Application for Planning Permission for Works or Extension to a Dwelling

Development: Demolition of existing garage/store and utility room and construction on the same footprint of a guest room and utility room. (This application may affect the character and appearance of the Angmering Conservation Area).

Location: Russetts High Street Angmering BN16 4AE

I regret that I am unable to accept your documents as a valid application until the following item(s) have been received or resolved :-

BLOCK PLAN SCALE 1/500
Proposed extension is shown shaded

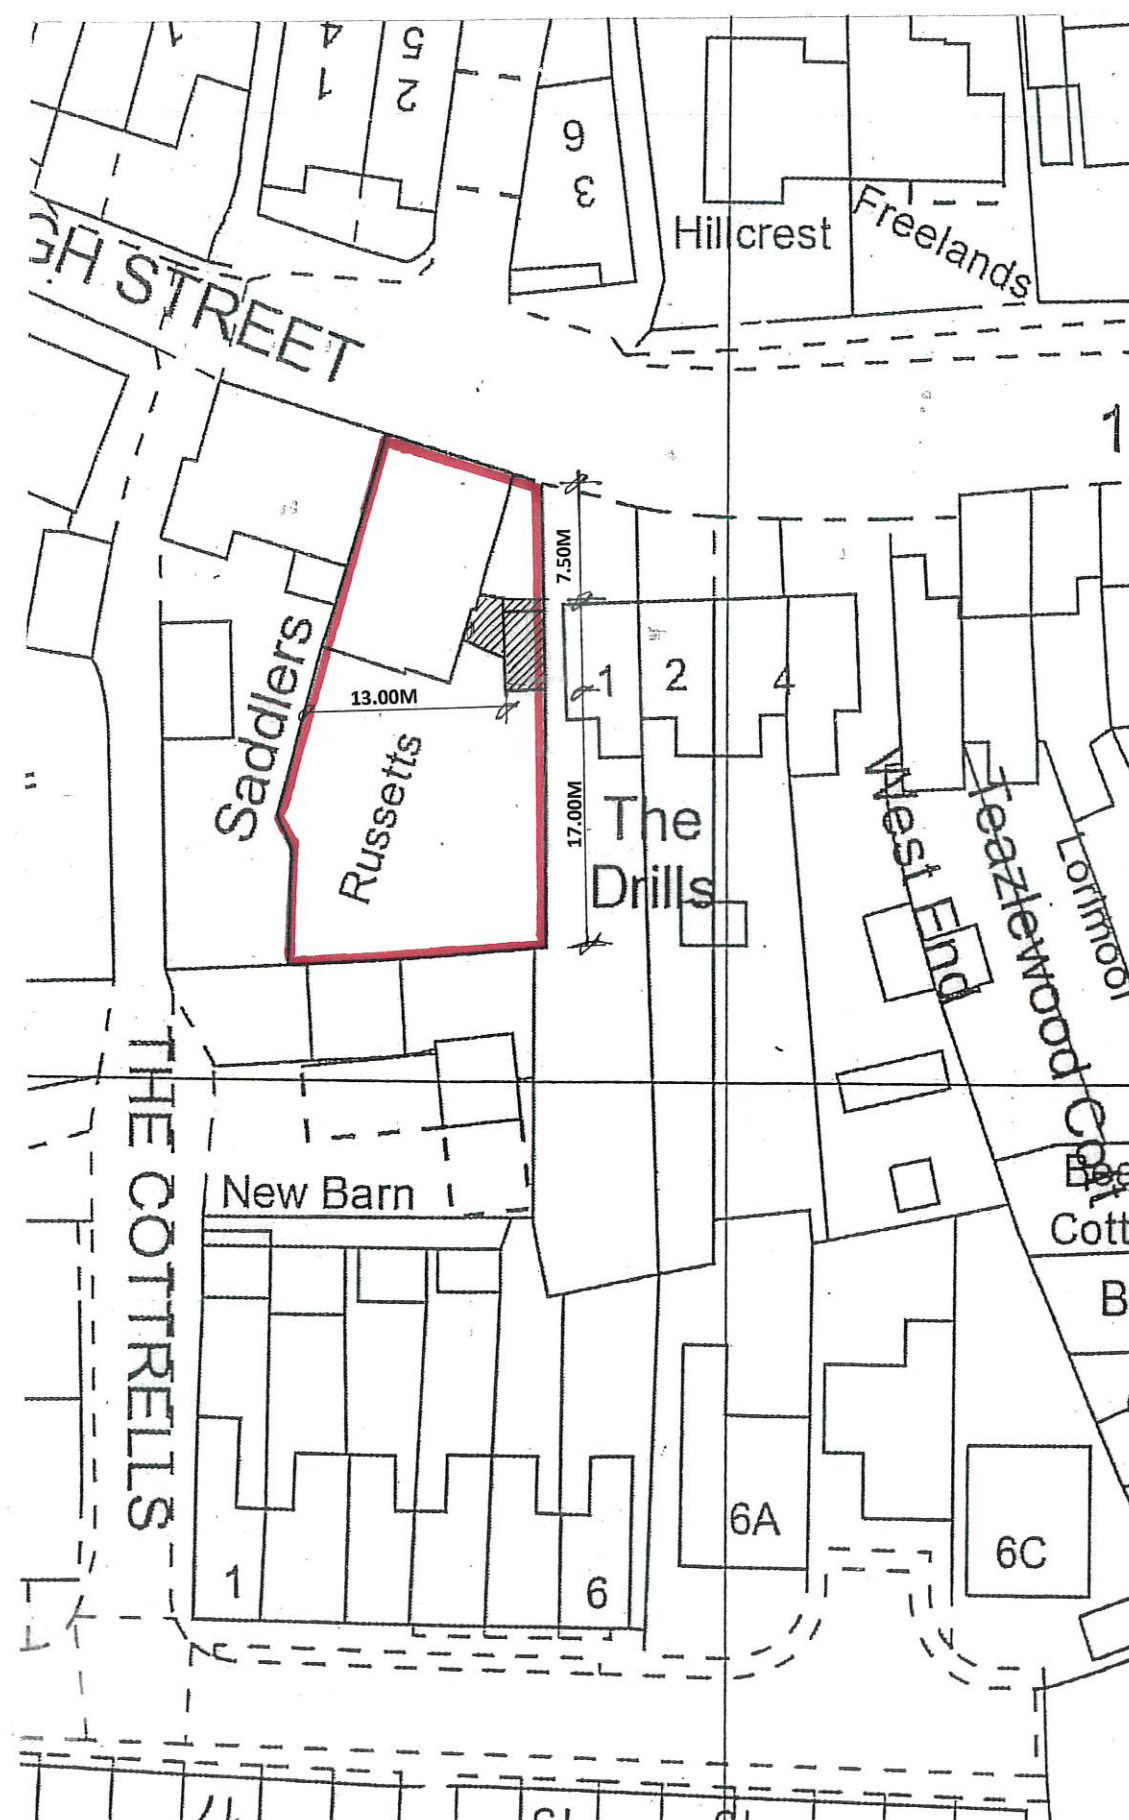
Block Plan

You are required to have dimensions from the proposed extension(s) to all site boundaries. Please amend

**EXISTING ELEVATIONS
GARAGE AND LOBBY**

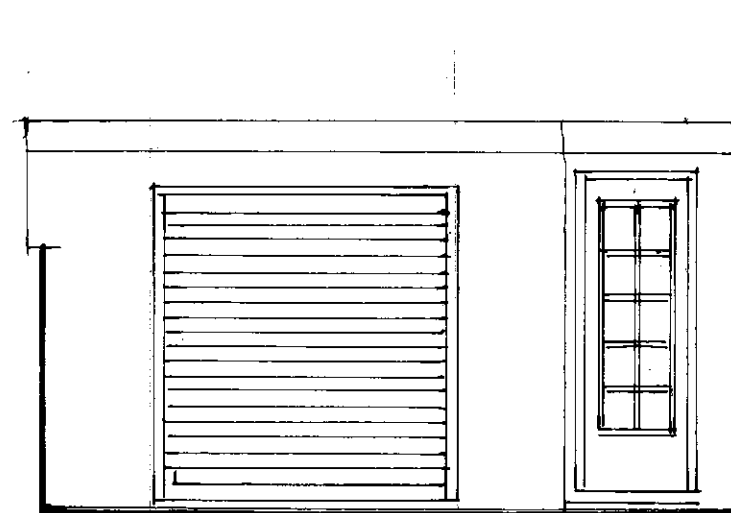
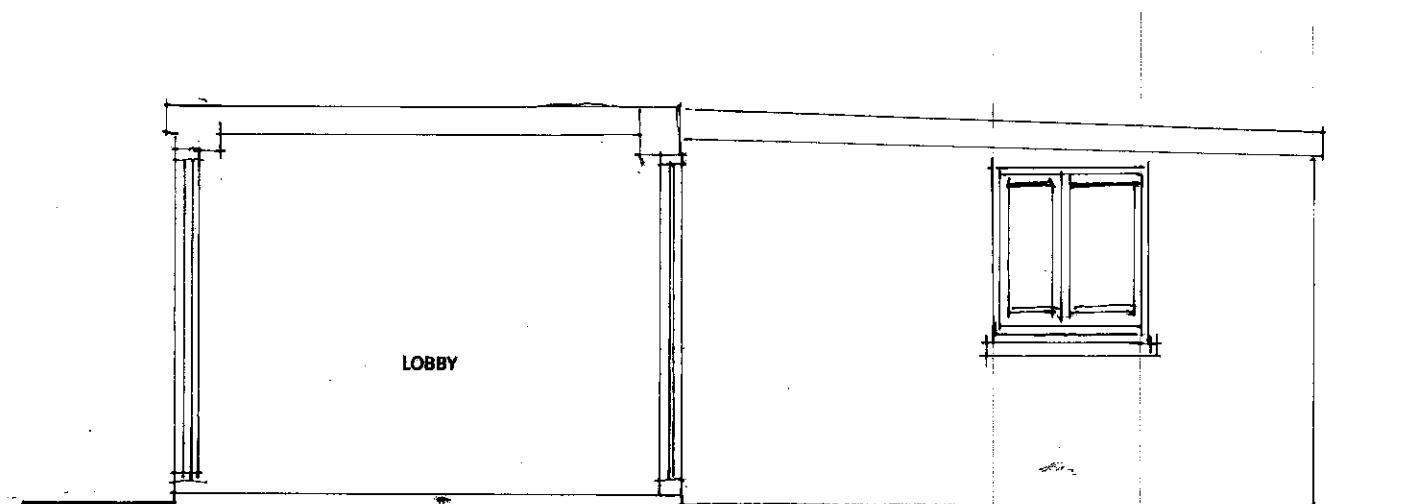
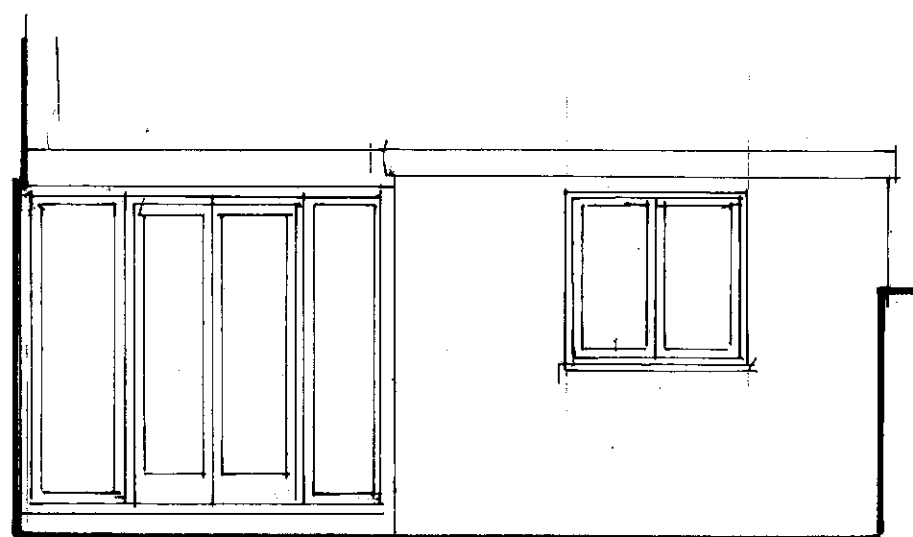
Elevations

Please submit electronic plans in pdf format clearly labelled existing elevations at a scale of 1:50 or 1:100. Further details can be found in the Validation Requirements List.

Please add a scale bar to all the plans and elevations.
